**From:** [Bruce Stidworthy](#)  
**To:** [Matthew Satches](#)  
**Cc:** [Harmon Rita T.](#); [Cherne, Curtis](#)  
**Subject:** Re: Sportsplex Weir  
**Date:** Monday, November 03, 2014 11:48:07 AM  
**Attachments:** [image001.jpg](#)  
[image002.jpg](#)

**Subject:** Sportsplex Weir

Would this weir configuration work? The rip rap was relocated to within the weir on our side of the property.

DATE: OCTOBER 30, 2014
**CONCEPTUAL
GRADING PLAN**

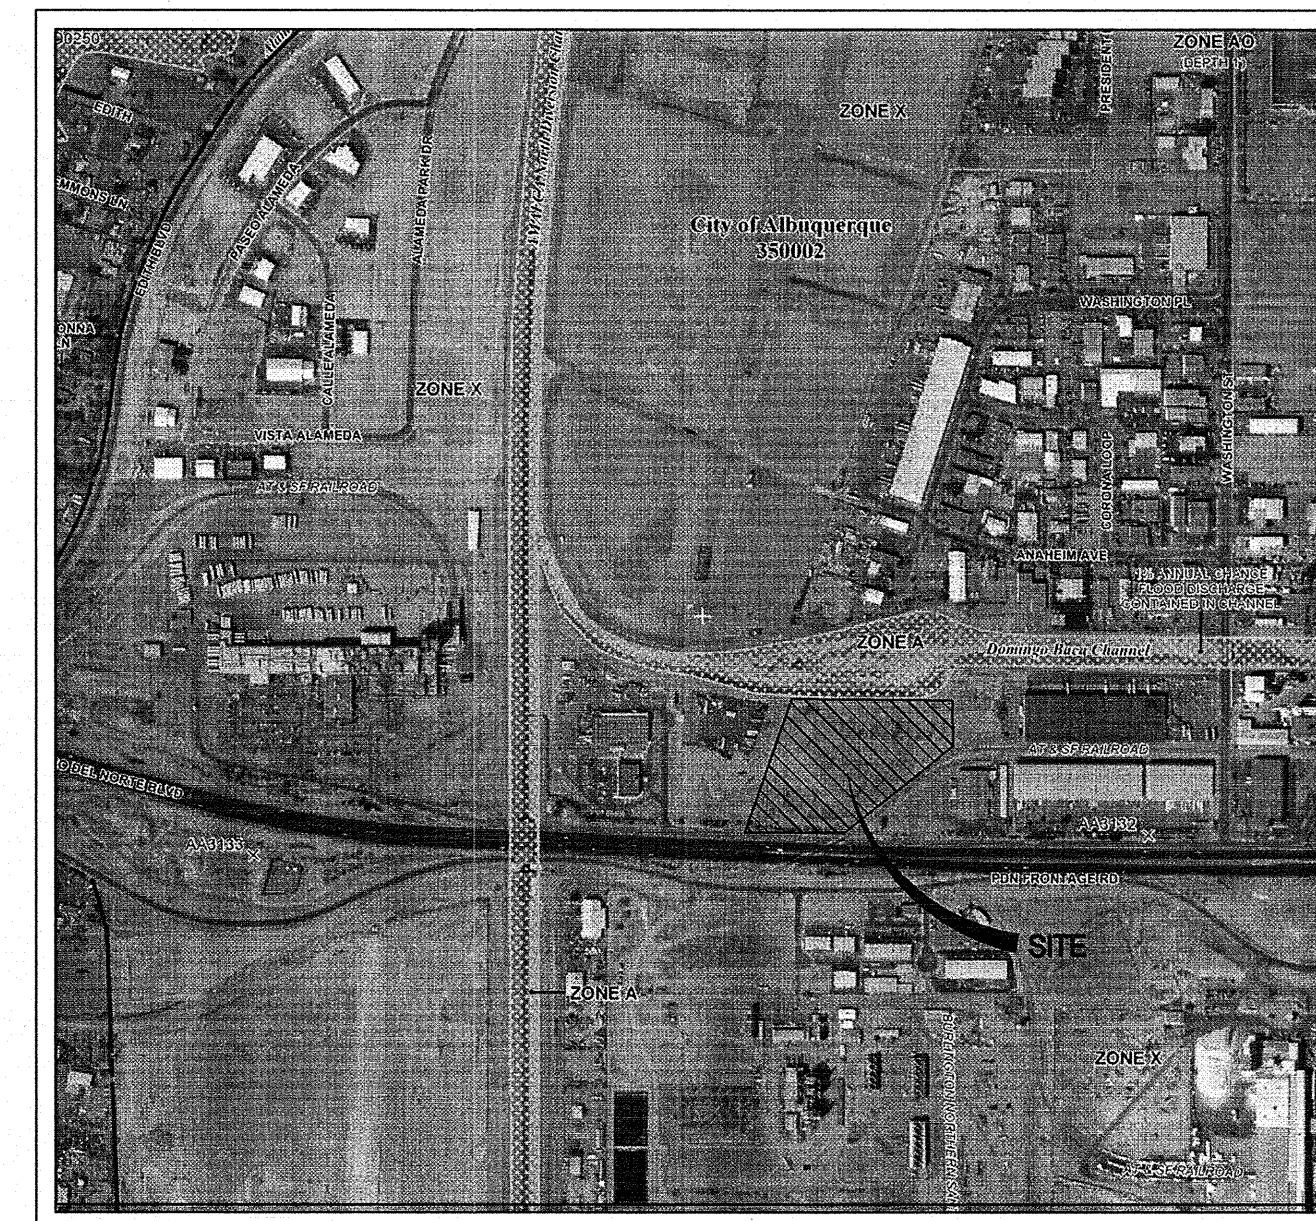
So that we can better understand the drainage of the decel lane, show spot elevations or contours. Indicate a water block.

Curtis, just to clarify a bit more we were thinking we would put a valley gutter where the existing curb and gutter is located and then slope the turn lane towards the valley gutter and put a water block at the driveway. That's how we have done most turn right turn lanes including some within DOT right-of-way.

I'll have the revised grading plan delivered this afternoon with the changes discussed.

As for the deceleration lane, we intend to have the drainage remain in the DOT ROW. We'll show a water block on our plans. More details will be provided once we are past the conceptual stages and submit to the DOT for formal review.

SECTION "B-B"
NTS
WEIR DETAIL

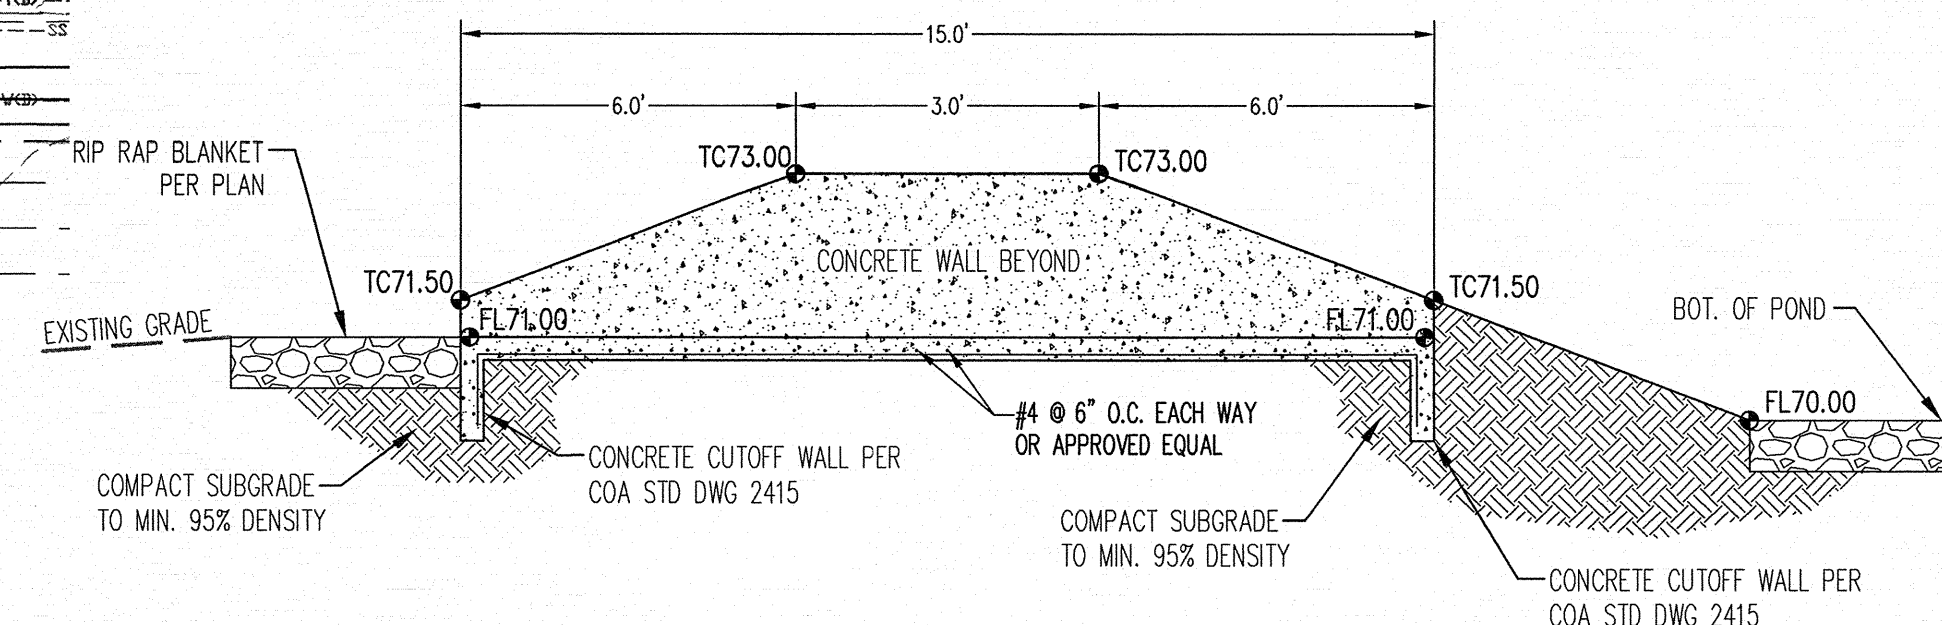
Looks good to me, go ahead and update the first sheet with the detail change as well as the other 2 changes we discussed ( the rail and the footing tow on one side of the property line.)

Are the dim's. correct? One side of the sloped concrete wall is 3' wide, and the other is 6', but they look symmetrical. Can you draw to scale.

I can't read the dimensions. What is distance from the 15' from property line to bottom of pond. Can you turn the image to a PDF.

The dimensions are correct, here's a slight update to reflect the steeper slope.

I've attached a PDF. The distance from the property line to bottom of pond is approximately 15'. This PDF has been revised to reflect accurate dimensions.
